From: Sarah Burrow <Sarah.Burrow@arun.gov.uk>
Sent: 05 January 2021 09:39
To: Planning.Responses <Planning.Responses@arun.gov.uk>
Cc: Zac Denton <Zac.Denton@arun.gov.uk>
Subject: RE: Planning Consultation on: M/89/20/HH

Engineers Comments Regarding Surface Water Drainage

Application No: M/89/20/HH
Registered: 16th November 2020
Site Address: 16 Manor Way Elmer Middleton-On-Sea PO22 6LA
Grid Reference: 498757 100078
Description of Works: Construction of two storey side extension, replacement windows and doors, internal re-ordering, external cladding and associated works

drawing
Floor Plans, Roof Plan and
Typical Cross Section
As proposed

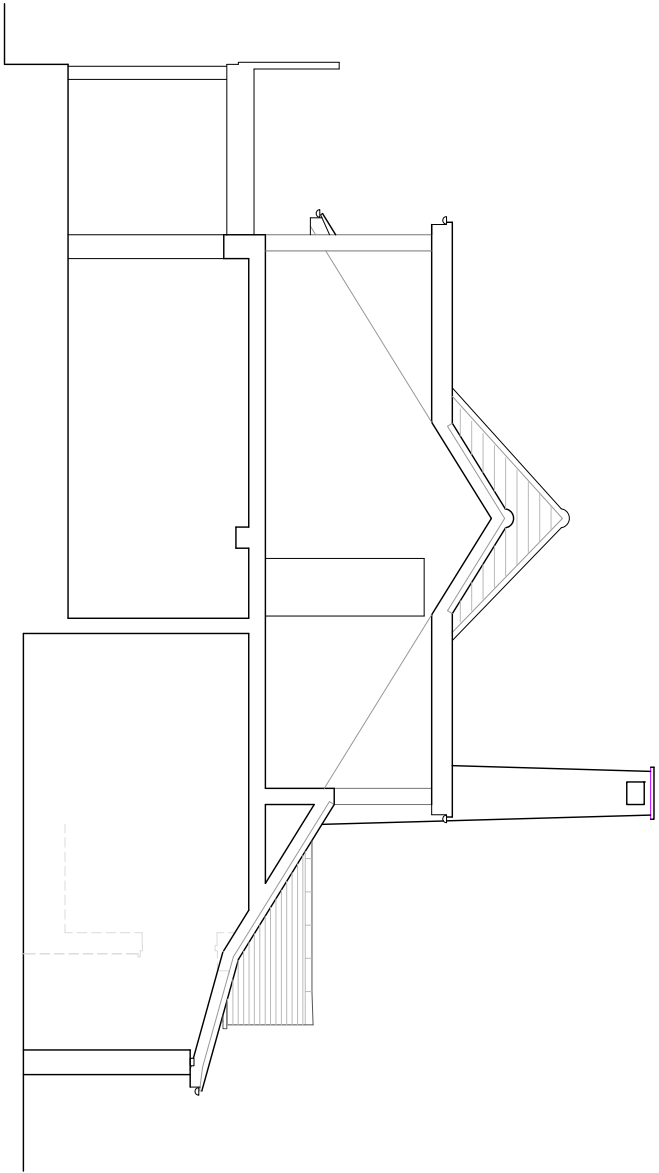
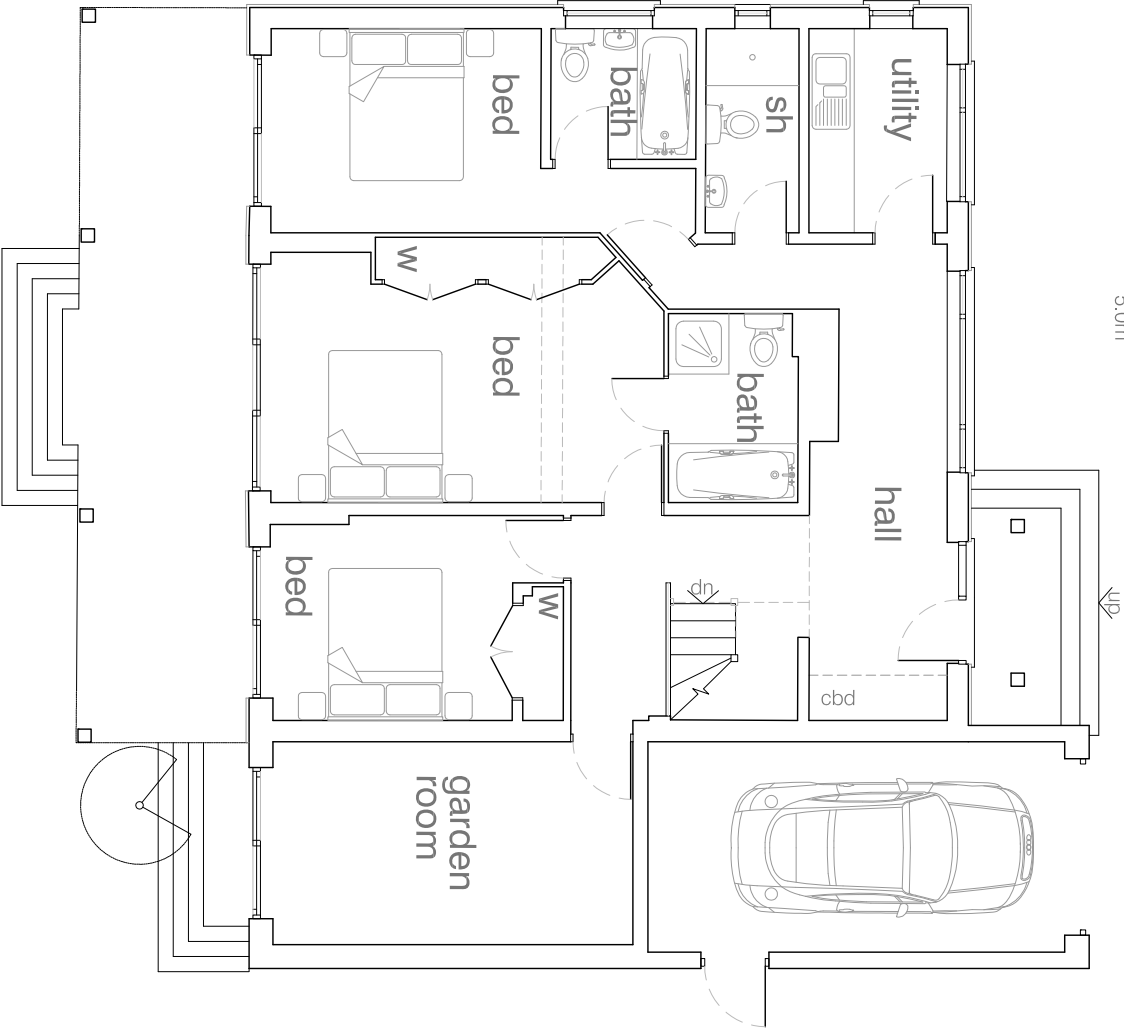
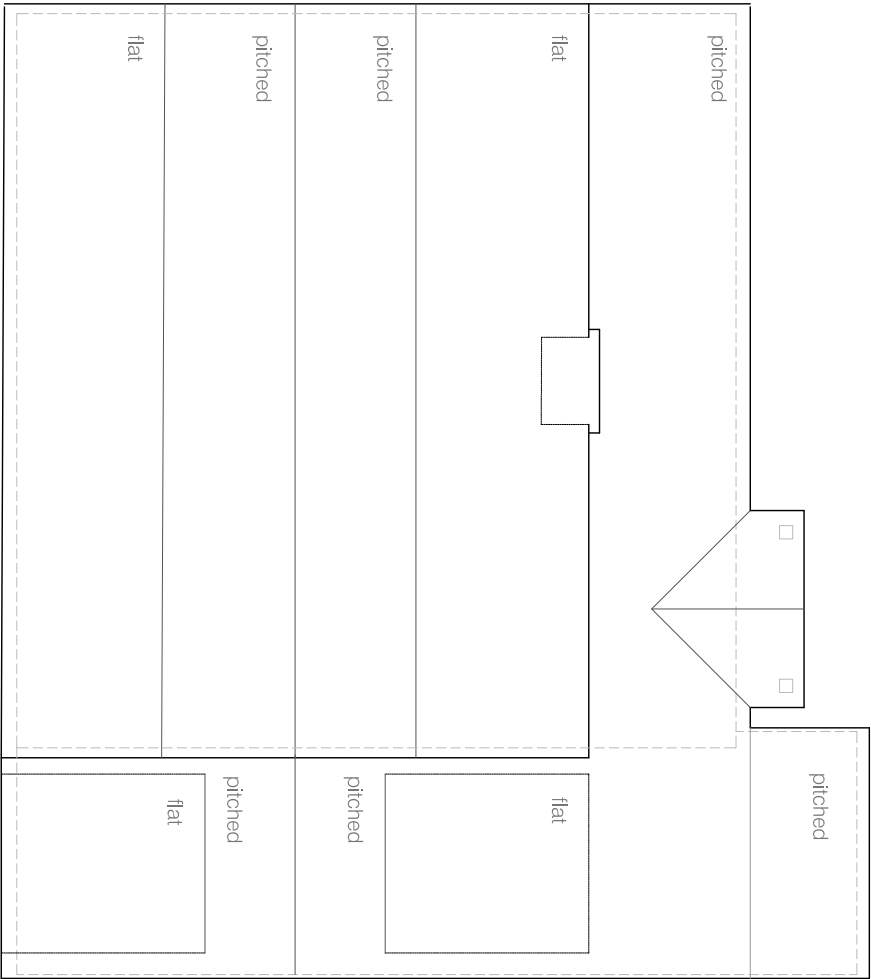
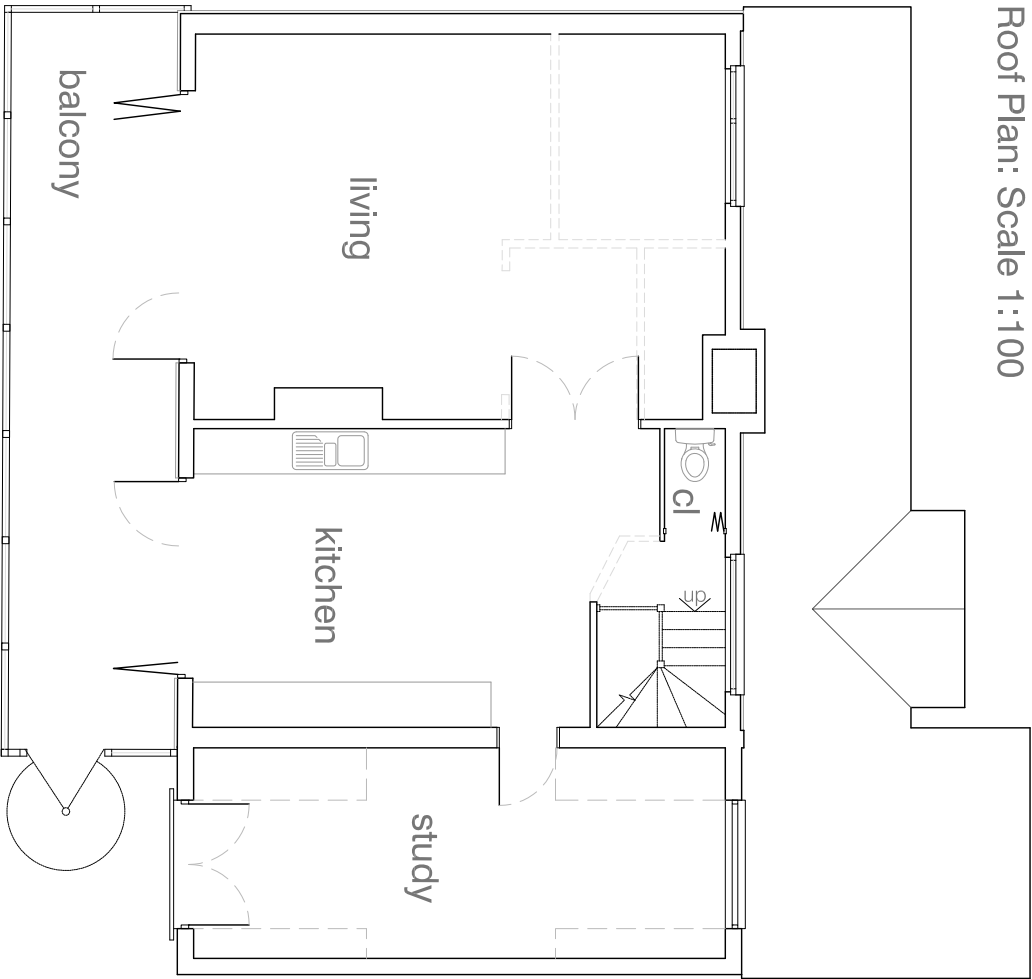
The applicant states in their Flood Risk Assessment that they intend to utilise existing surface water downpipes to drain the roof of the new extension. This is not appropriate without further investigation. The proposed development lies in the Lidsey Treatment Catchment and the alternative to infiltration would likely be to discharge surface water to the foul network which is already at capacity and we would strongly oppose.

It is assumed that the primary flood source is tidal. On this basis and on the basis of the Environment Agency defences at Elmer which mitigate risk, we will accept sustainable drainage features in this location and would expect to see infiltration fully investigated. The hierarchy for sustainable drainage must be followed.

The proposed development lies in the Lidsey Treatment Catchment and the alternative to infiltration would likely be to discharge surface water to the foul network which is already at capacity and we would strongly oppose.

If you are minded to approve this application please apply standard condition PCENG2 to ensure that the development is adequately drained and does not increase flood risk elsewhere.

"Development shall not commence, other than works of site survey and investigation, until full details of the proposed surface water drainage scheme have been submitted to and approved in writing by the Local Planning Authority. The design should follow the hierarchy of preference for different types of surface water drainage disposal systems as set out in Approved Document H of the Building Regulations, and the recommendations of the SuDS Manual produced by CIRIA. Winter groundwater monitoring to establish highest annual ground water levels and winter Percolation testing to BRE 365, or similar approved, will be required to support the design of any Infiltration drainage. No building / No part of the extended building shall be occupied until the complete surface water drainage system serving the property has been implemented in accordance with the agreed details and the details so agreed shall be maintained in good working order in perpetuity."
